Your Ref: OWPC4598
Our Ref: FG/165/14/HH 18-11-2014
Please ask for:
Mr D Sullivan

Single storey detached garage (resubmission following FG/132/13/).
29 The Poplars Ferring

Thank you for your internet representation made on 20th December 2014 which has been recorded as '**an objection**' with the comments as follows:

Proposed floor & roof
plans & elevations

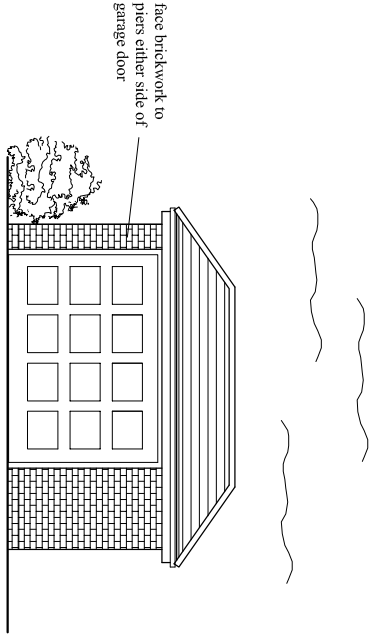
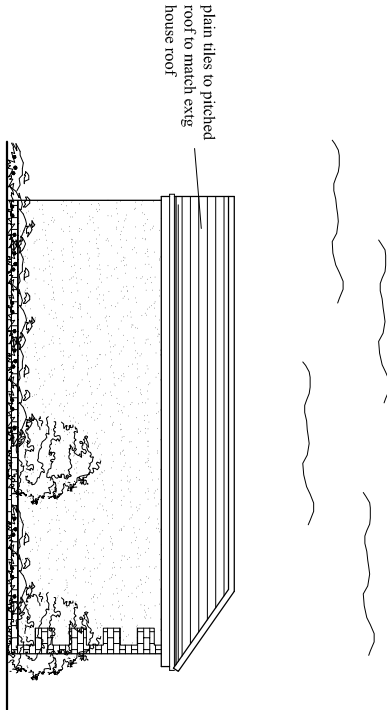
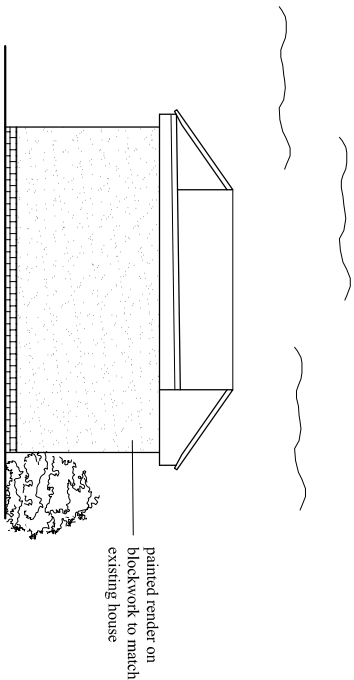
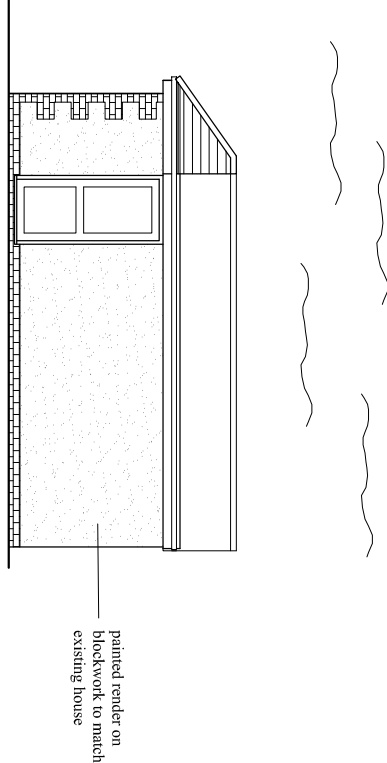
- 1) That the height of the construction will block sunlight and cast shade during the afternoons into my garden and patio area and will be at least 3ft above the height of my fence inside my boundary.*
- 2) The proposed construction is too close to existing boundary (.15m) which would not allow enough space to construct, render or paint and upkeep in the future.*
- 3) The proposed construction is not in building line of the owners property.*
